Fosse Green Energy

EN010154

9.31 Applicant's Response to Deadline 5
Submissions

12 May 2026

Indicative Fixed South Facing Site Layout Plan

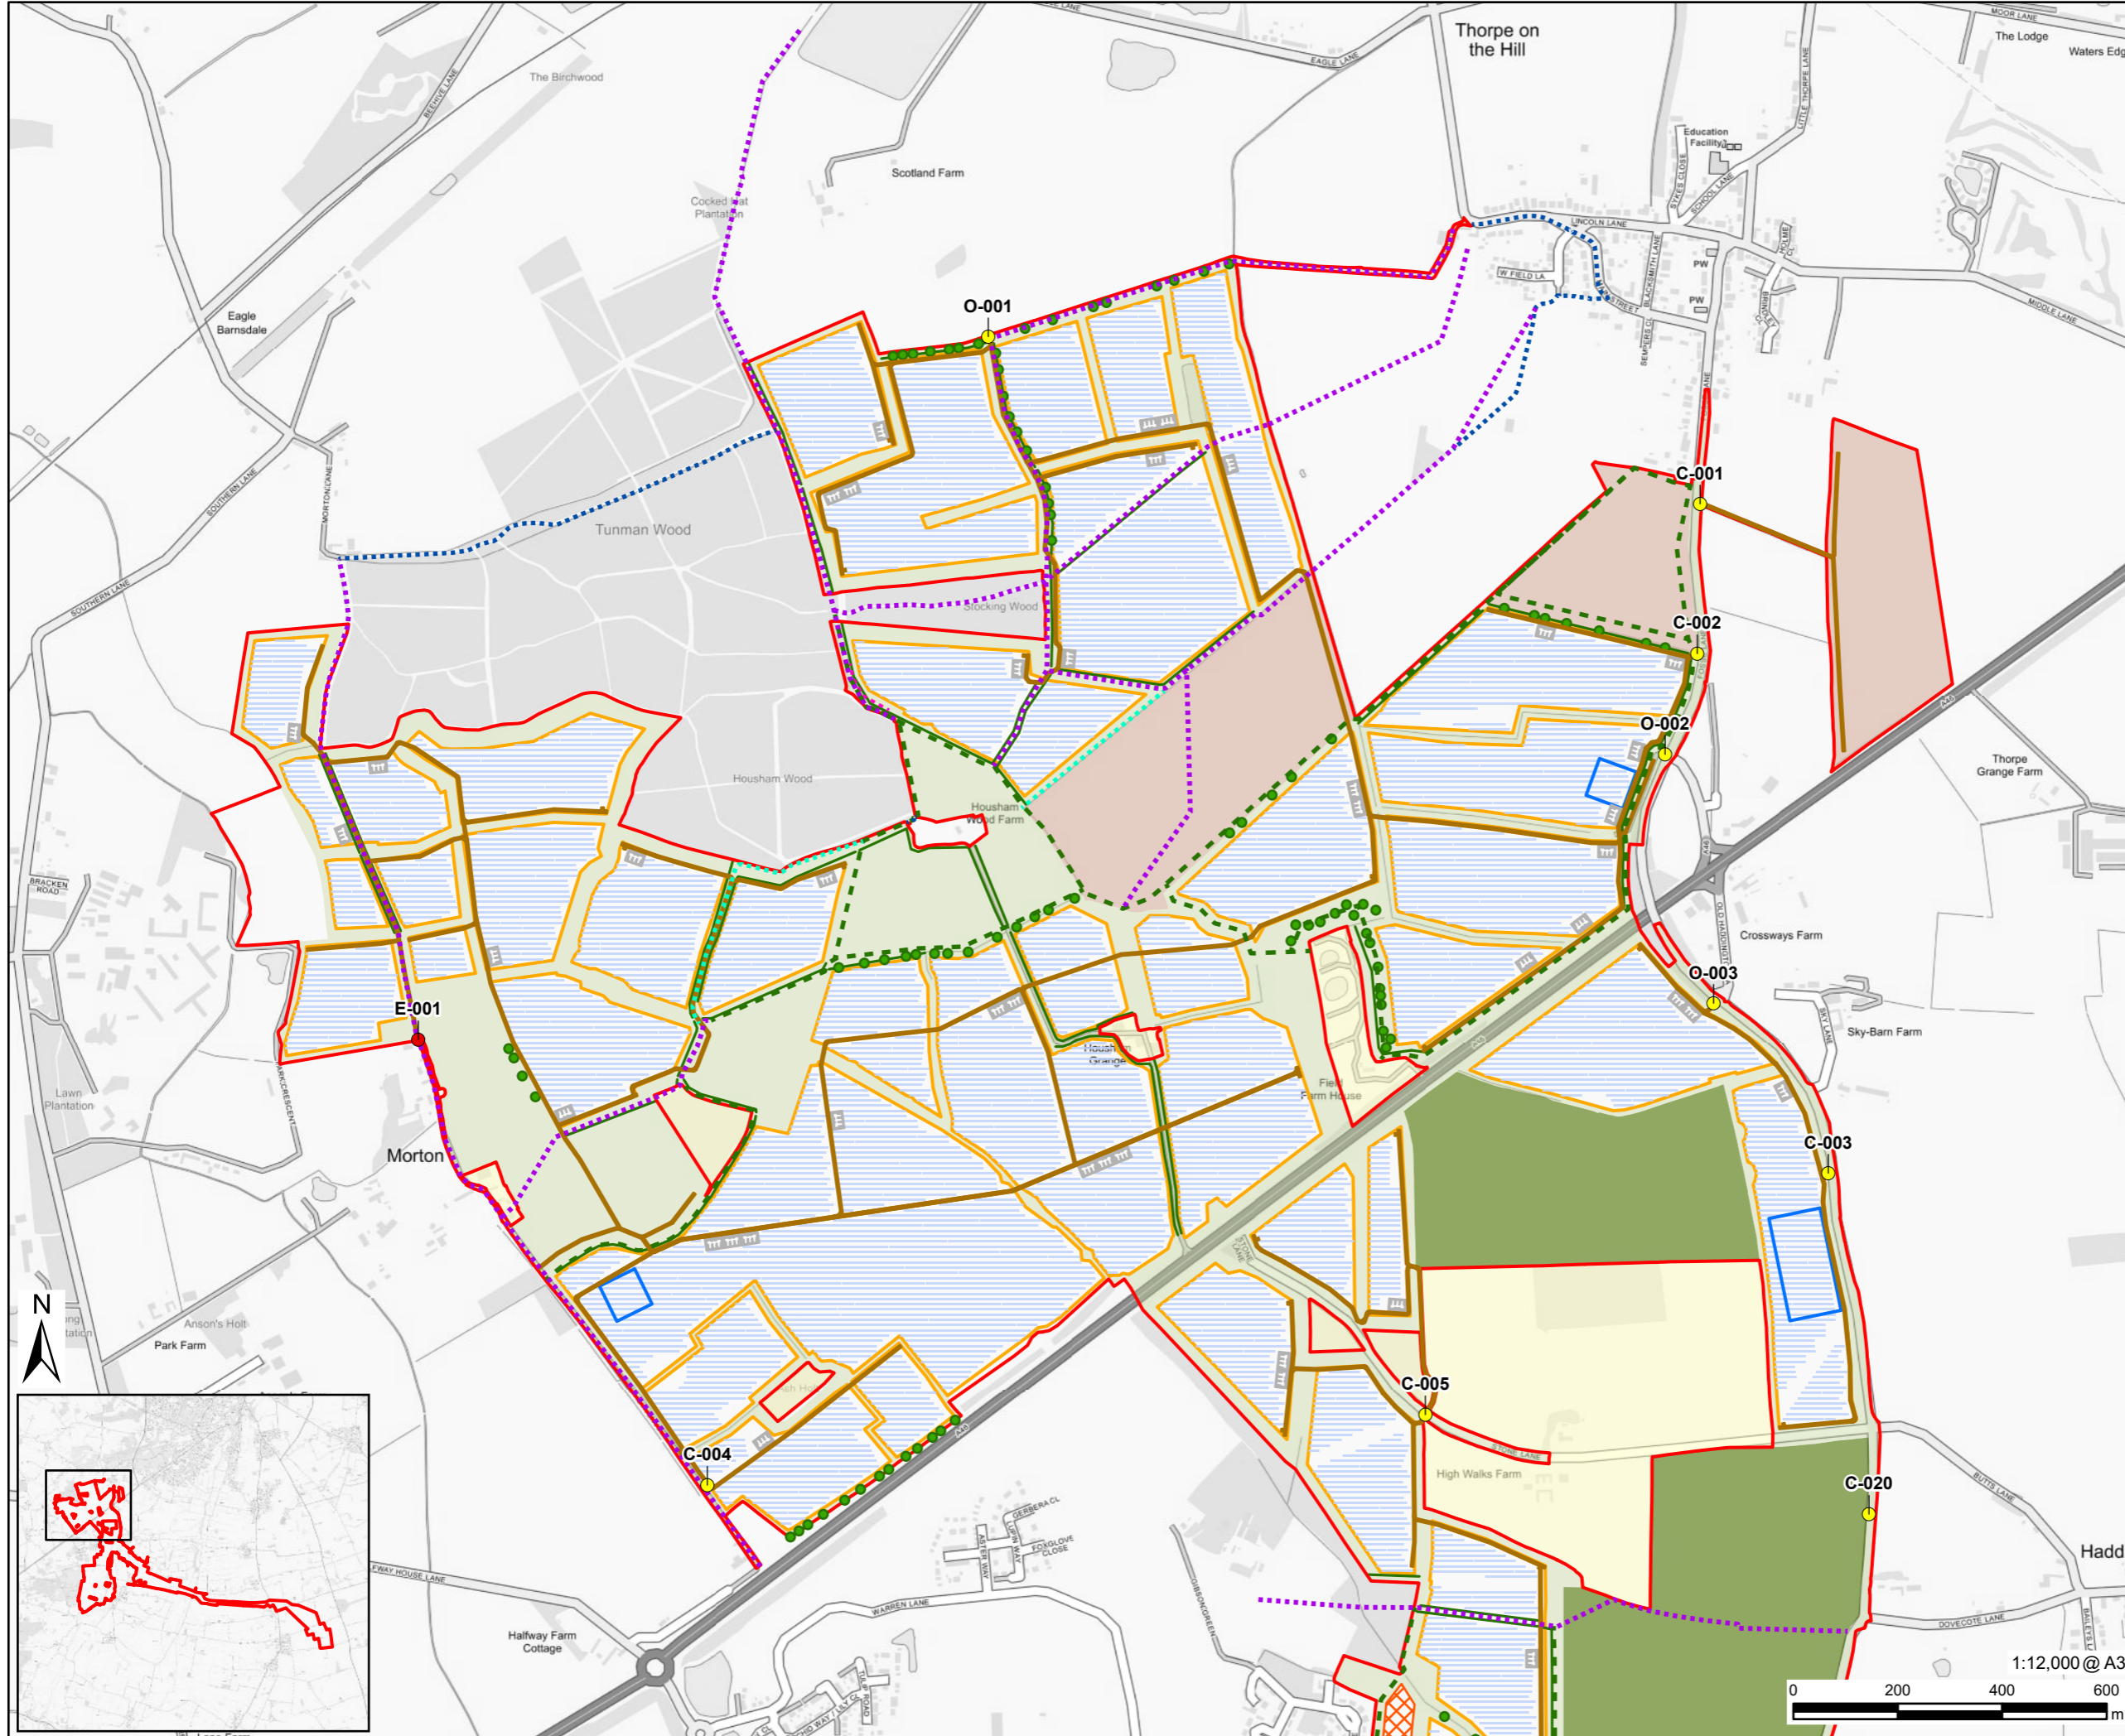
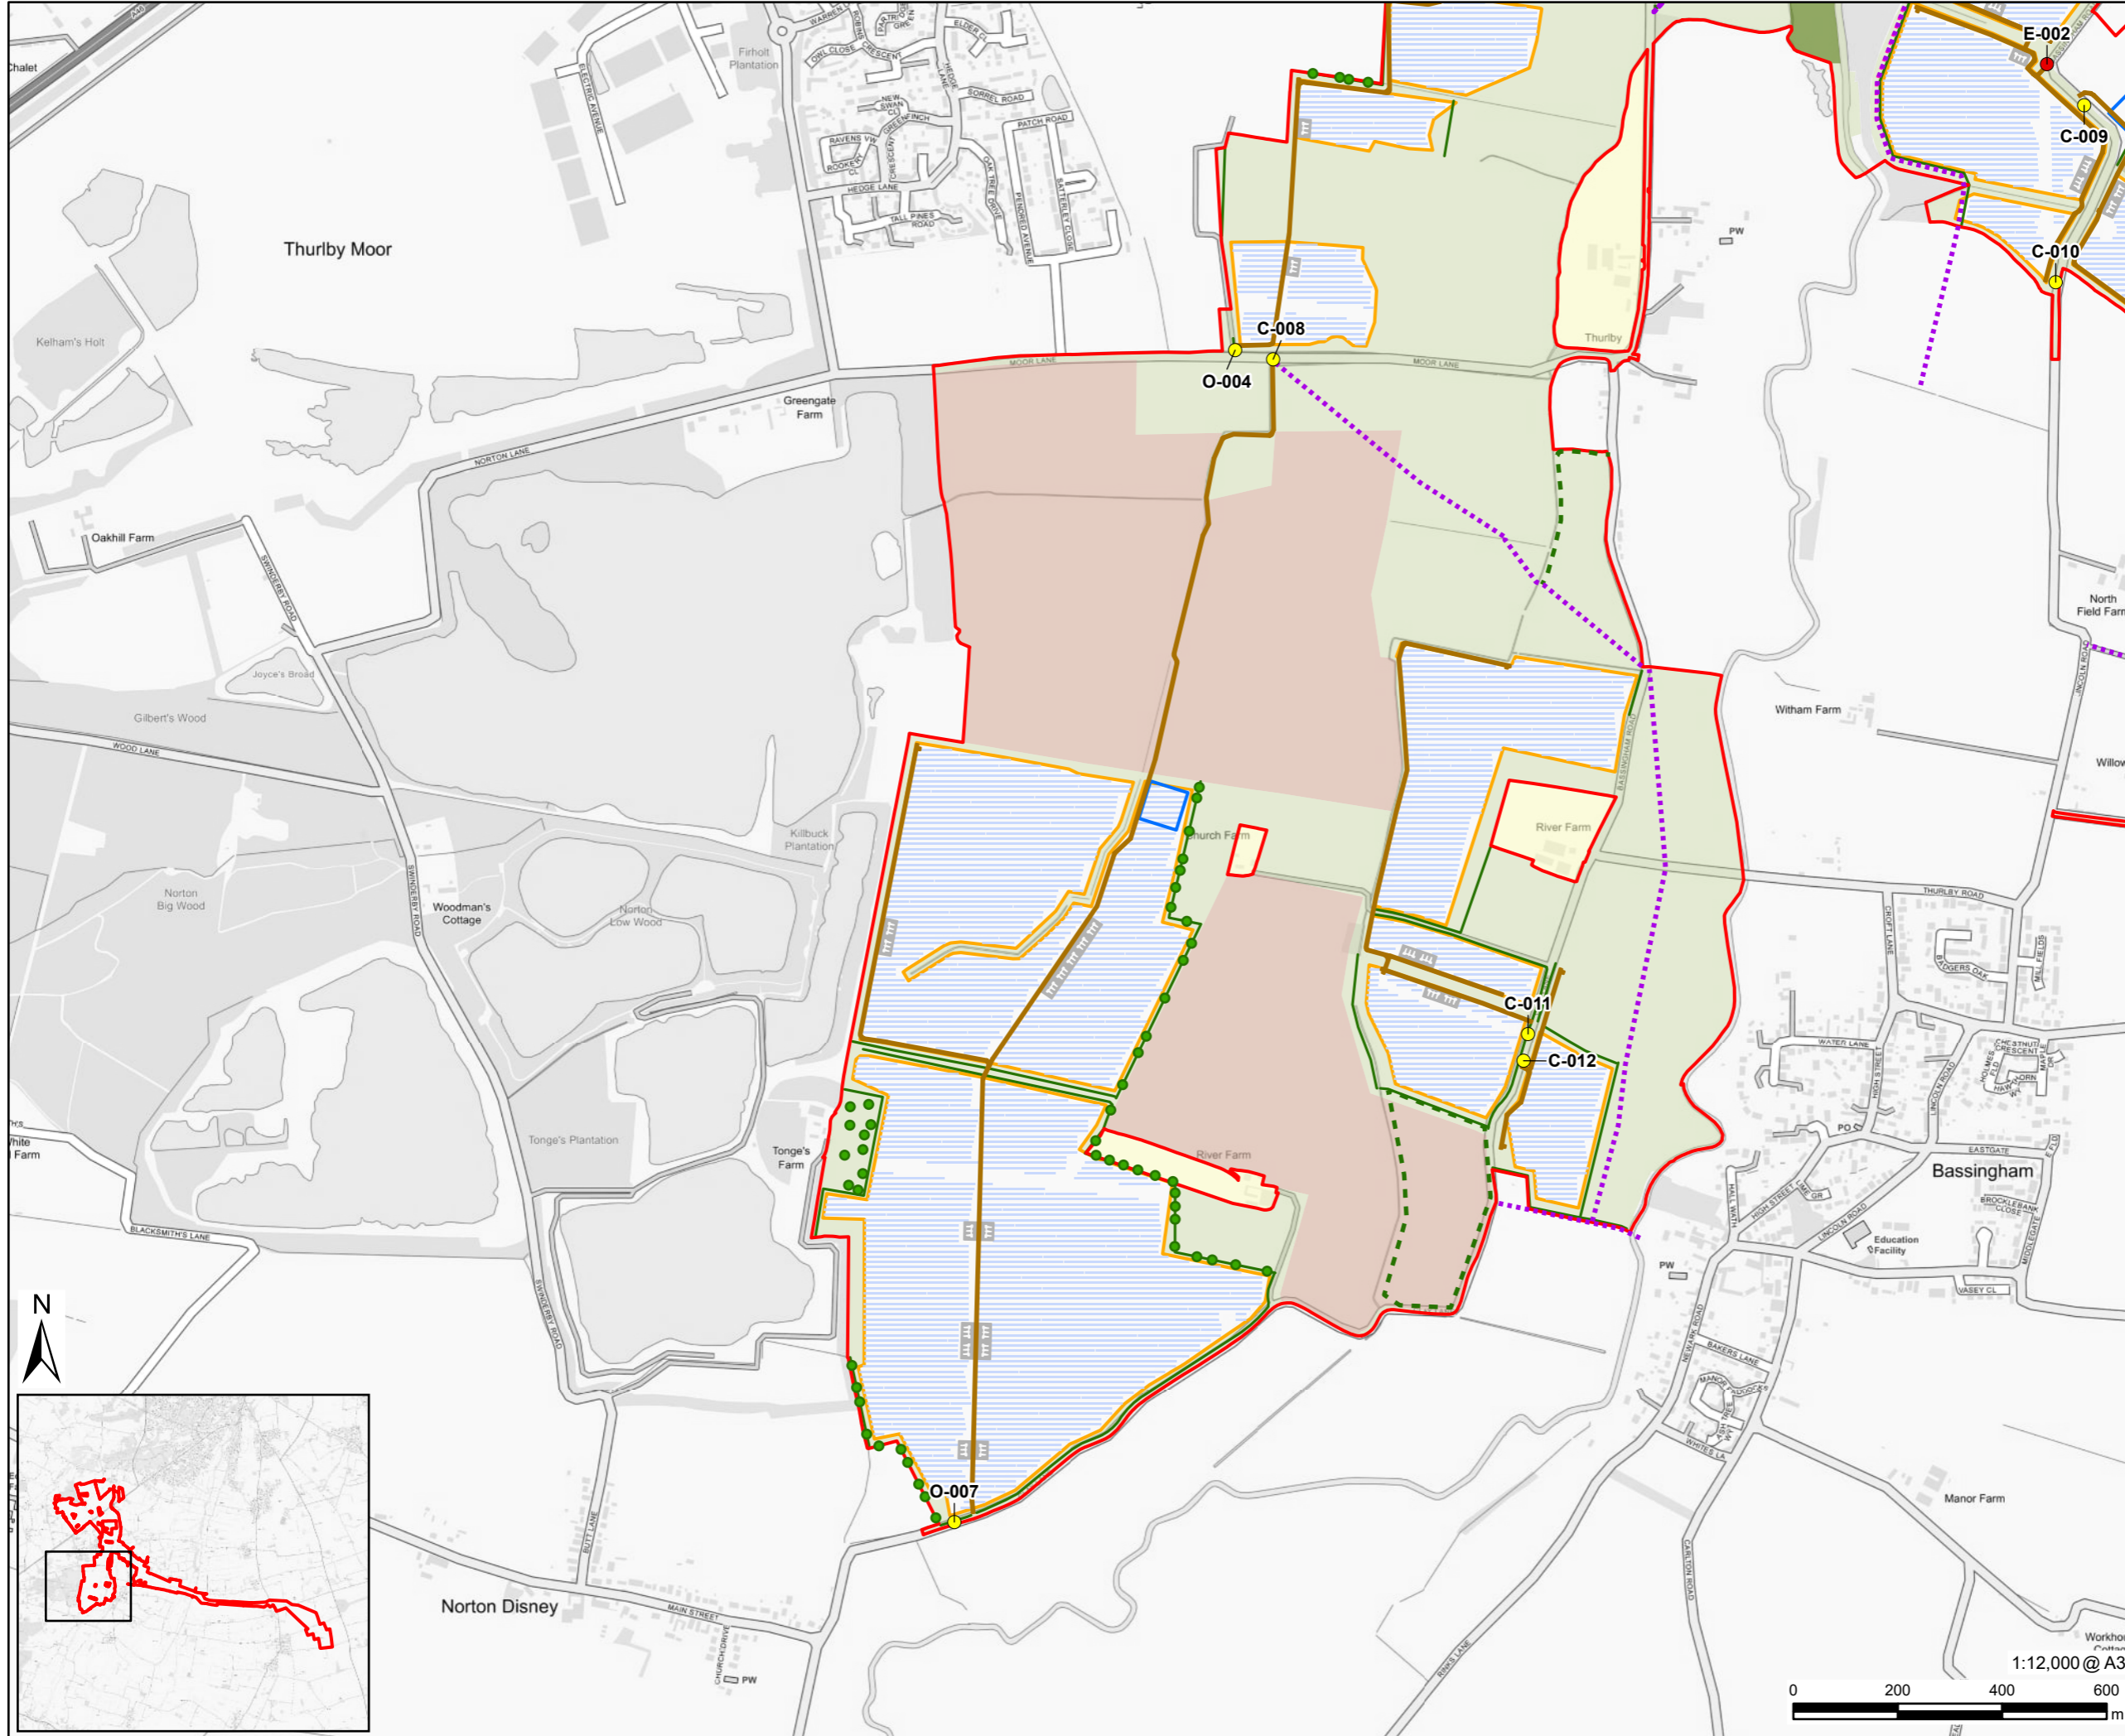
Interested Party	Theme	Comments from any party on any submissions and any information received at deadline 4	Applicant Response
LCC	Comments on D4 documents - Layout	Site Layout Plan Revisions - Indicative Fixed South Facing Layout (Rev 3) and Indicative Single Axis Tracker Layout (Rev 3) [REP4-006 & REP4-007, respectively) LCC assumes that the overall red line boundary remains unchanged, and thus LCC's previous comments in respect of minerals & waste safeguarding remain unchanged.	The assumption that the DCO Site red line boundary remains unchanged is correct. The Applicant's position regarding minerals and waste safeguarding are set out the Applicant's Response to Deadline 4 Submissions [REP5-025], the Applicant's Response to the Examining Authority's First Written Questions [REP2-029] and the Applicant's Response to Deadline 2 Submissions [REP3A-025].
LCC	Comments on D4 documents - FCEMP	Framework Construction Environmental Management Plan (Rev 5) [REP4-009] LCC notes and appreciates the addition of paragraph 2.2.3 which states the applicant will inform LCC of the date of final commissioning once it has occurred. Section 2.9: Recovery, Recycling and Disposal of Waste – No changes to comment on here, but we note that the Table of Contents mistakenly labels this as 'Section 2.8'. In respect of archaeology LCC's previous comments stand, including that 'The full extent of any preservation in situ areas or areas identified for further archaeological work will need to be fenced off to ensure that there are no groundworks, plant movement, storage or any other developmental works which may cause damage to the currently surviving archaeology.' Within Table 2, cultural heritage, CH-C1 states that 'The detailed CEMP(s) will include an action plan detailing the required mitigation in the event that unplanned activities threaten the preservation of known buried archaeological remains.' Again, this will also need to include unevaluated areas as well as known archaeologically sensitive areas. This document makes reference to Environmental and Ecological Clerks of Work, as stated in our previous comments, an Archaeological Clerk of Works is also required.	Regarding an Archaeological Clerk of Works, it should be noted that CH-C1 of the Framework CEMP [REP5-011] notes that "If deemed necessary, an Archaeological Clerk of Works can be agreed." Matters of temporary or permanent fencing to protect known or potential buried archaeological remains are referenced in the draft Framework WSI [REP3A-027] (at paragraph 3.19) The Framework CEMP [REP5-011] correctly identifies the section 'Recovery, Recycling and Disposal of Waste' as Section 2.8 within the Table of Contents and within the document itself.
